CITY OF ALBUQUERQUE

March 8, 2016

**RE: APS Career Enrichment Center
807 Mountain Rd. NE
Requested for 30-Temporary C. O. - Accepted
Engineers Stamp Date 12/3/14 (J15D001)
Certification dated: 3-2-16**

GRADING PLAN

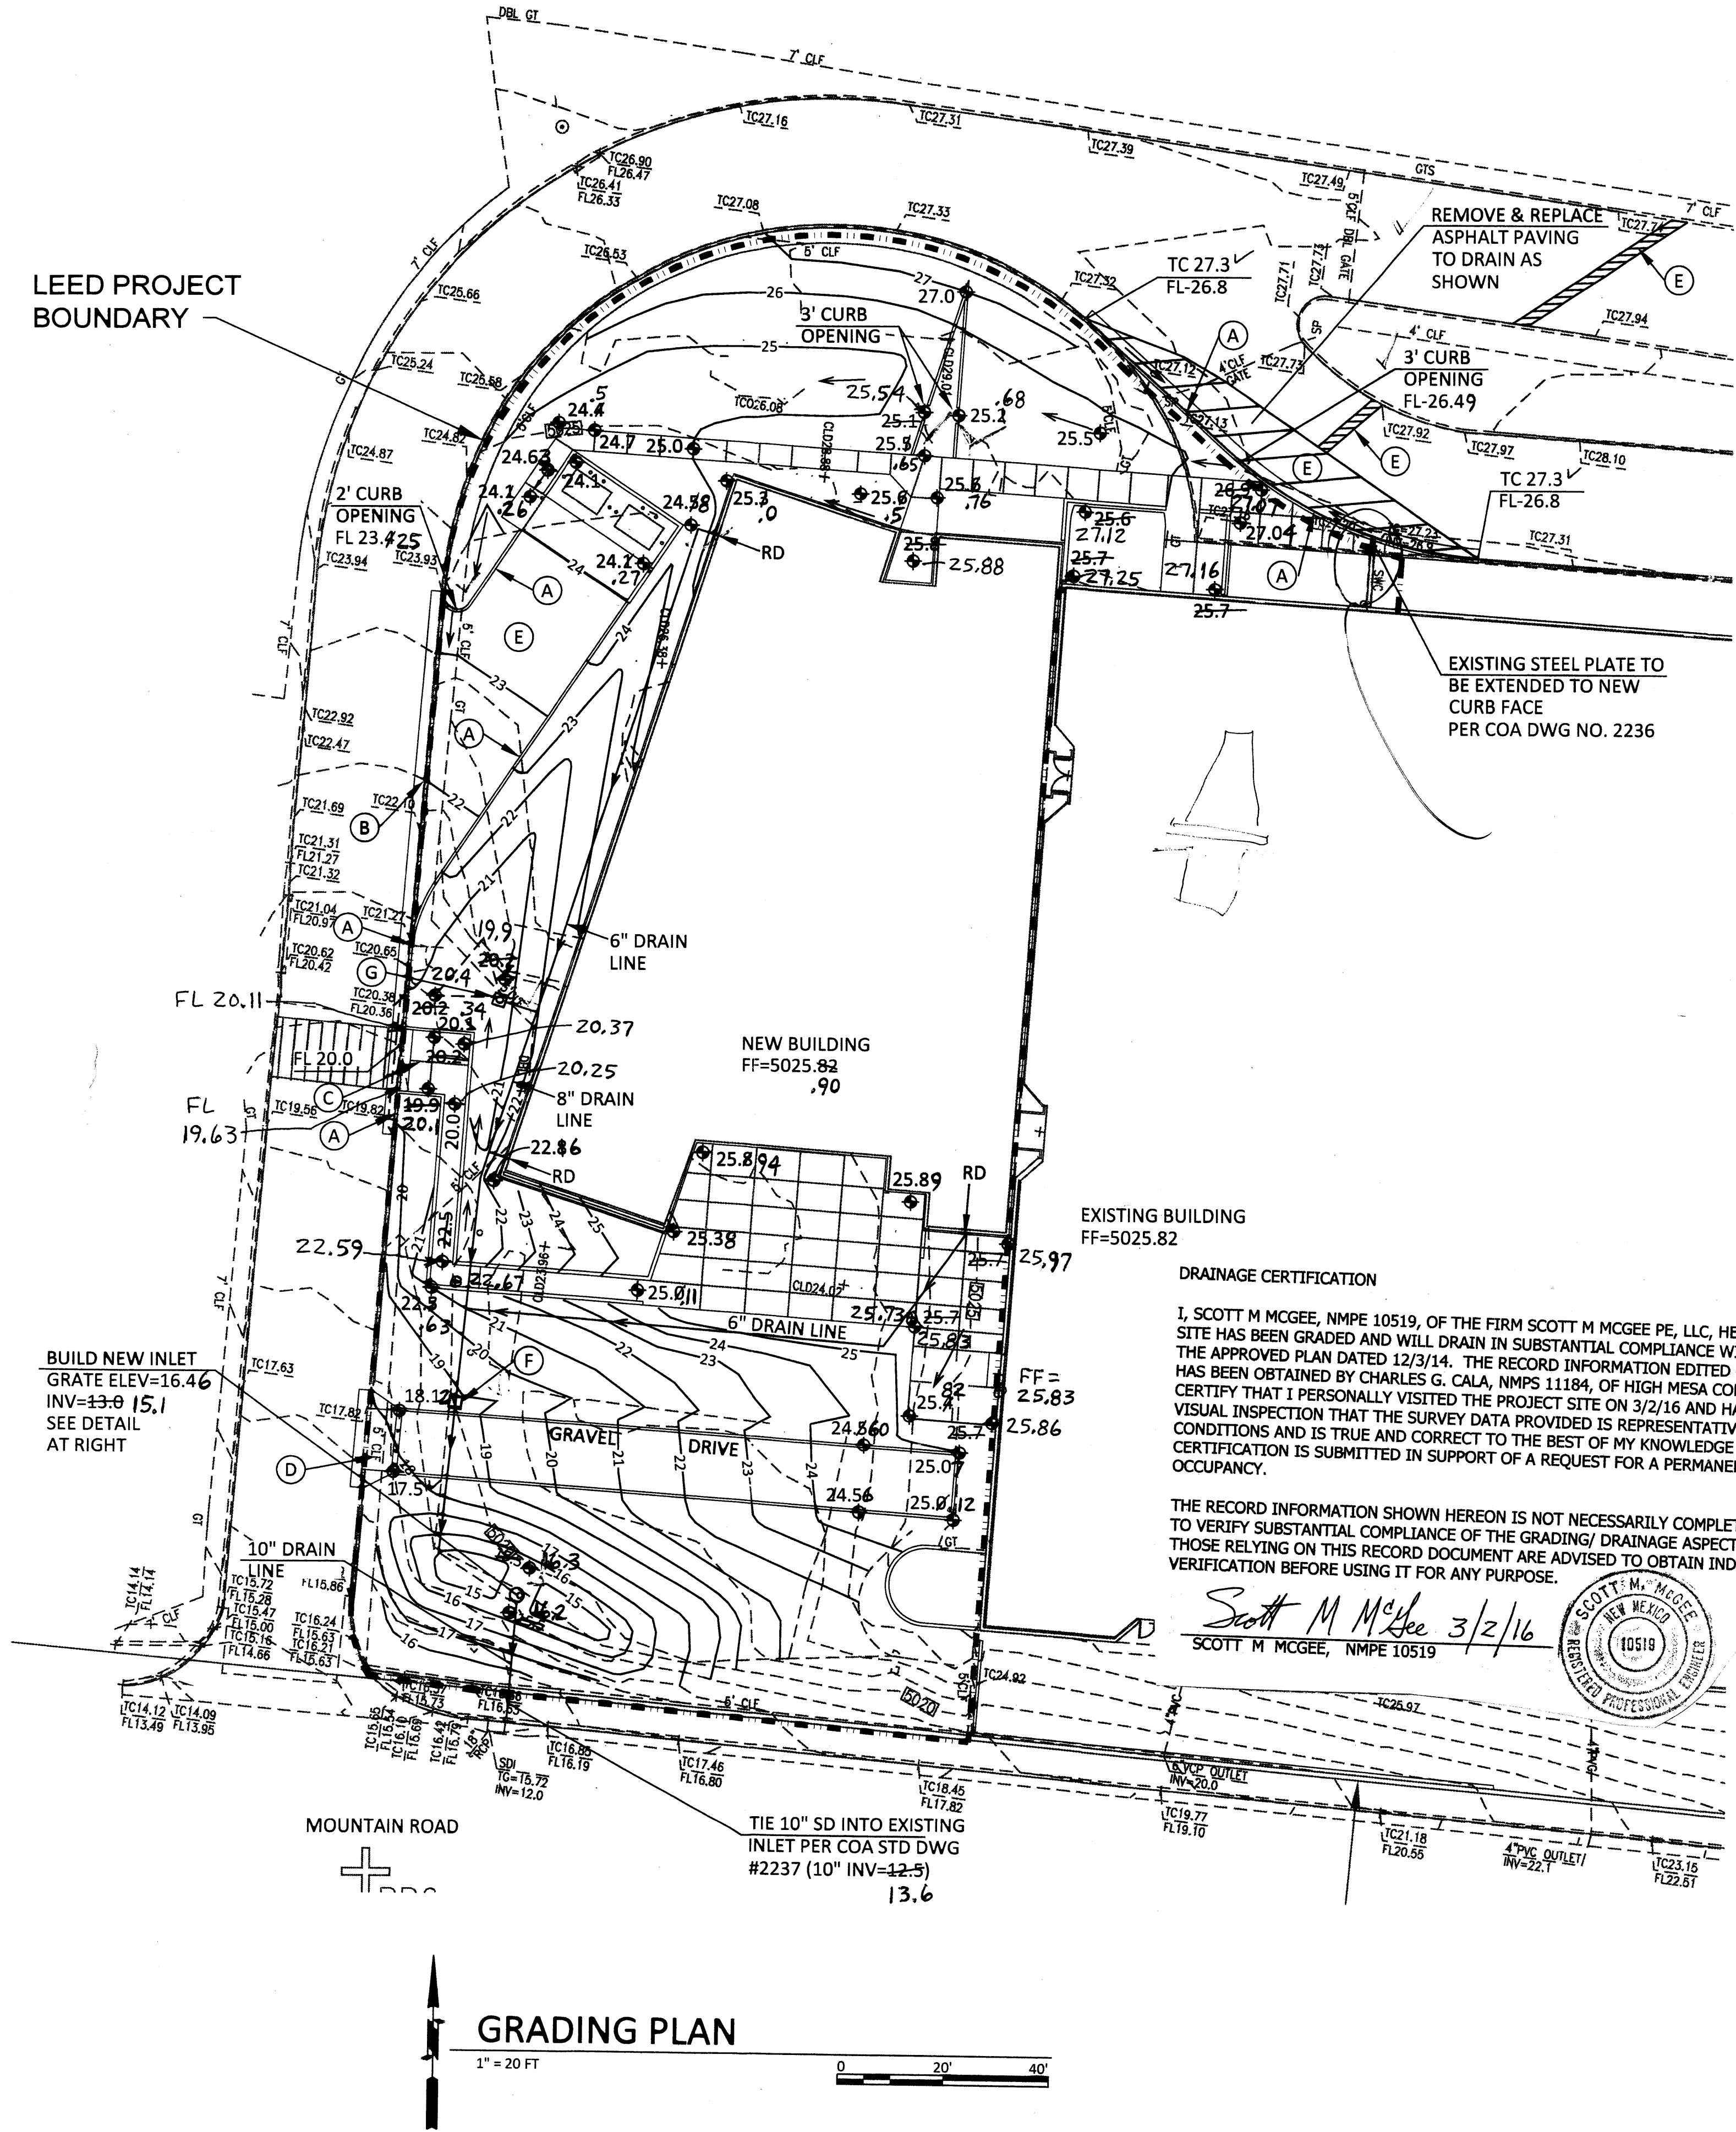
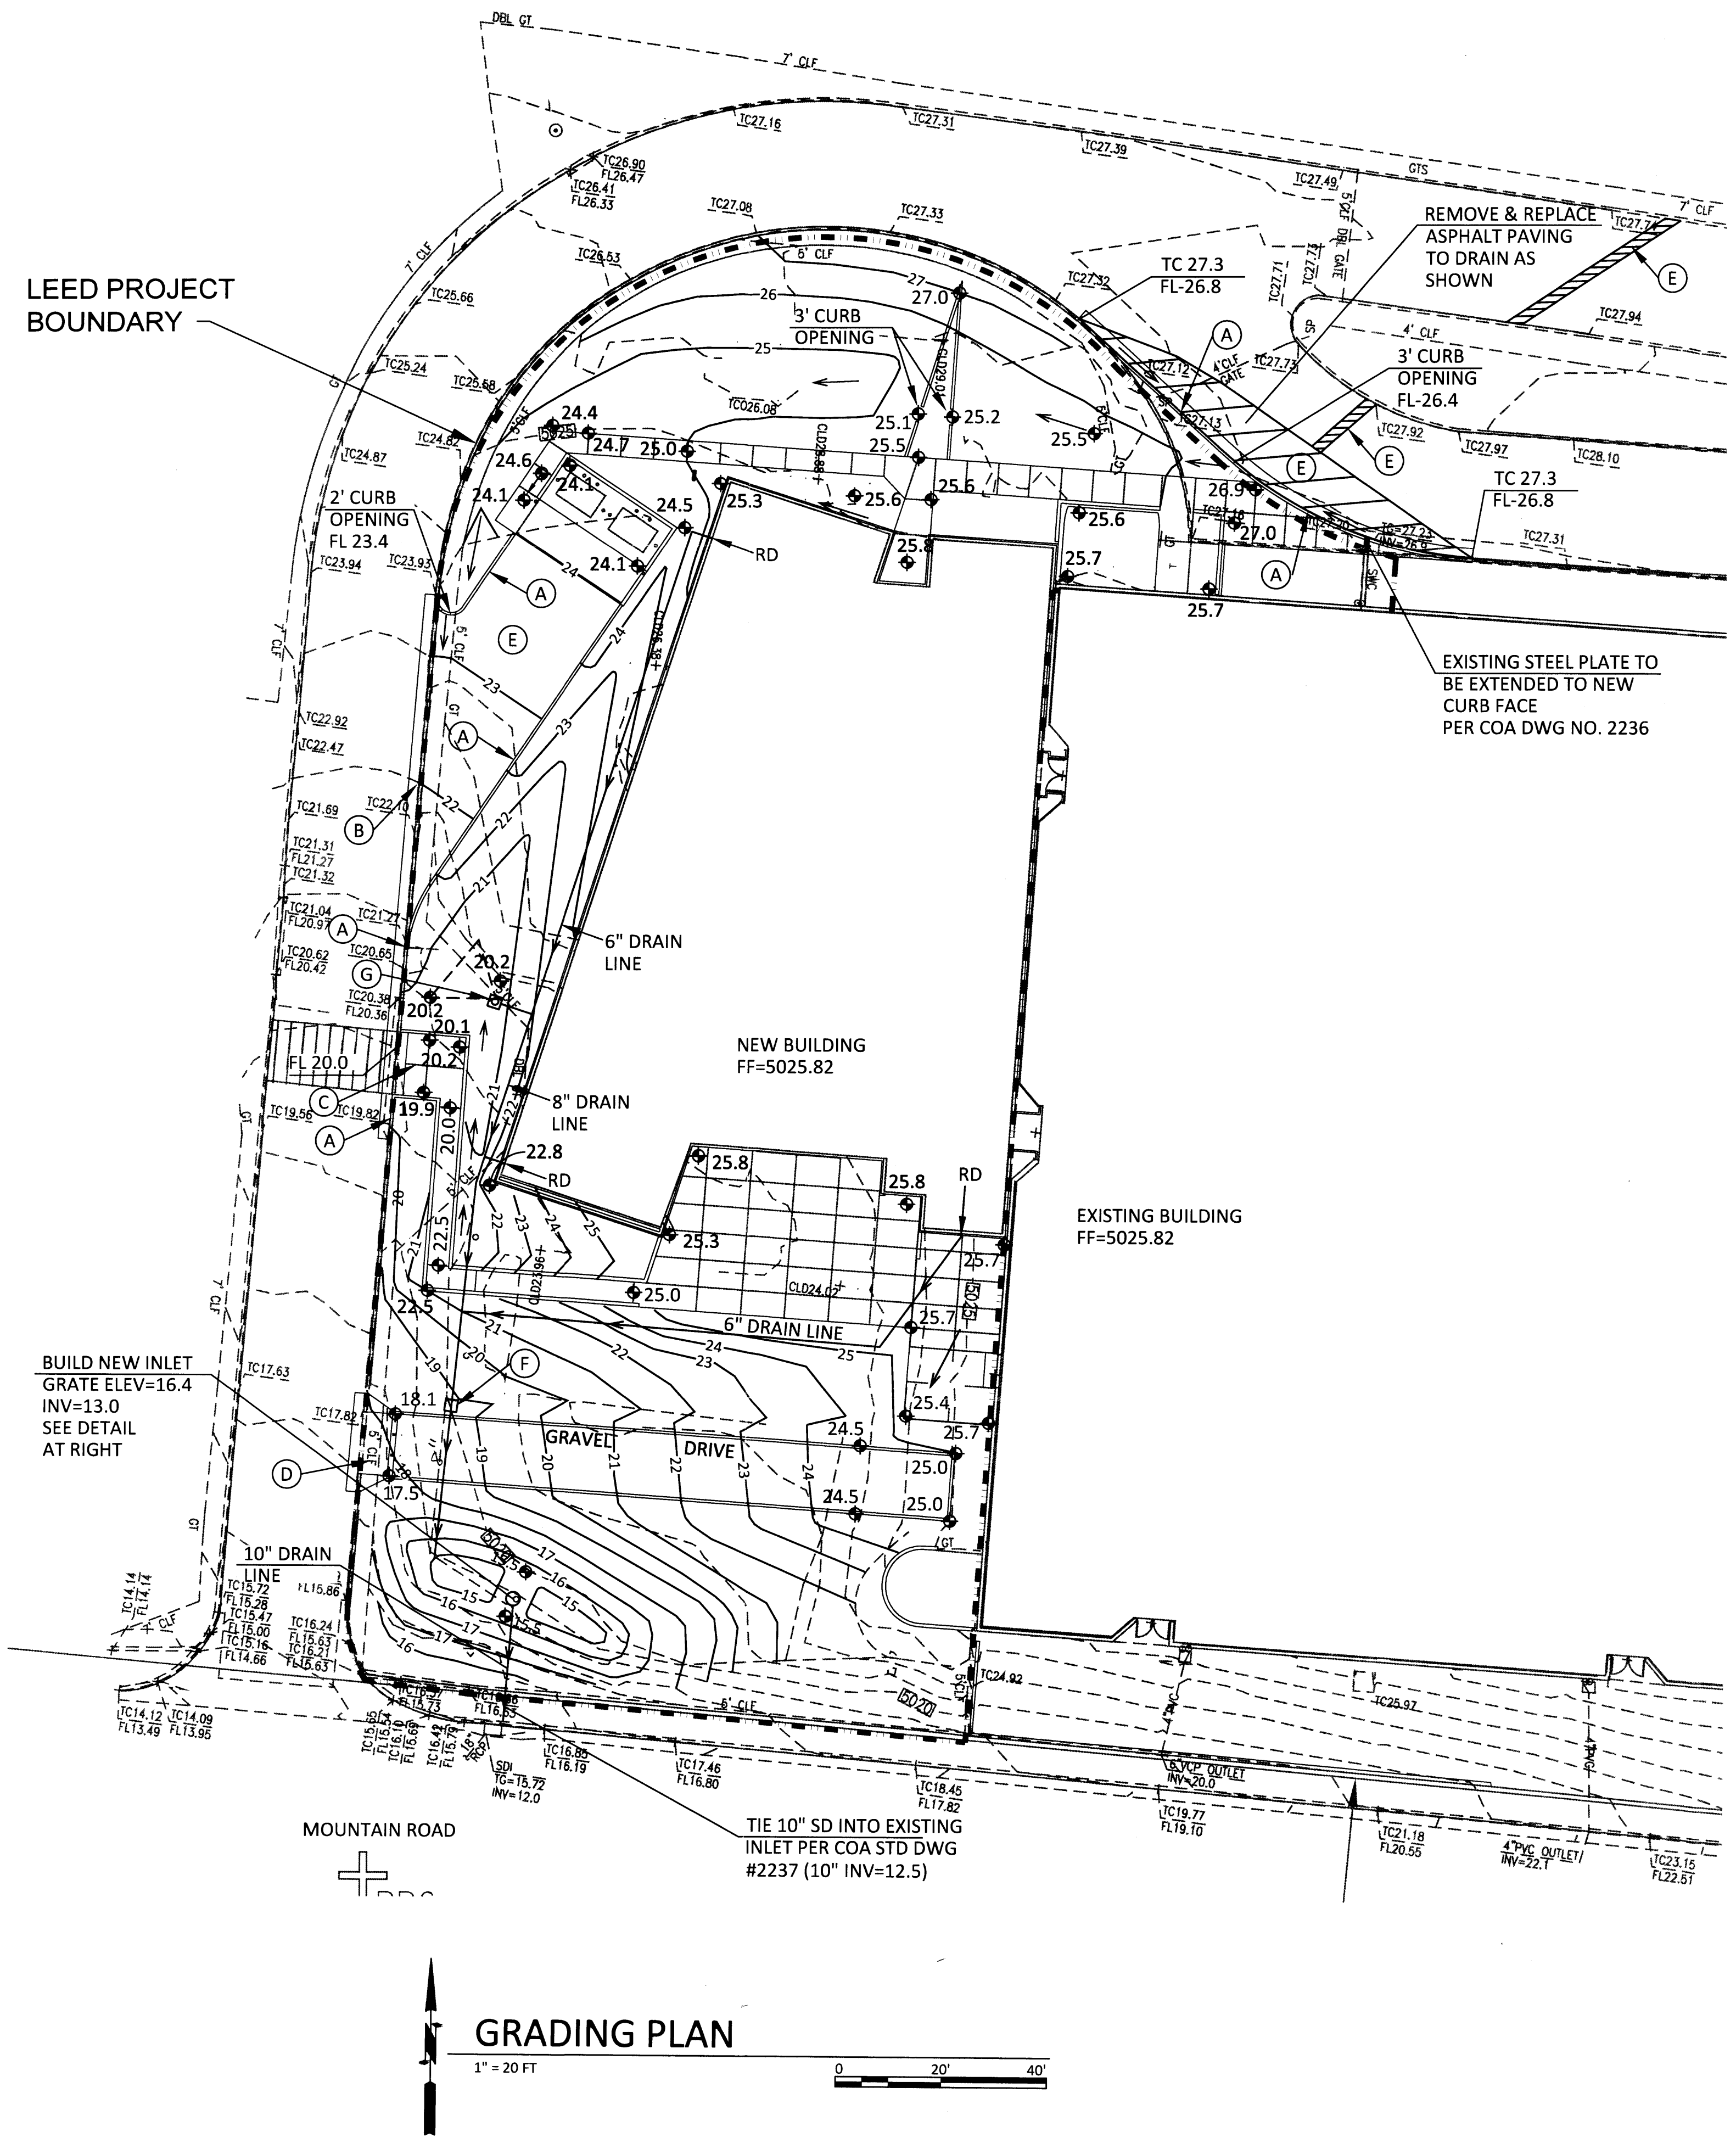
- On the north side of the building the existing steel plate has not been extended to the new curb face.
- On the drawings there is a roof drain called out on the south side of the building. That area is behind a locked enclosed area and I was unable to verify the roof drain.
- There is an existing manhole south of the new pond with the cover tipped up presenting a hazard.
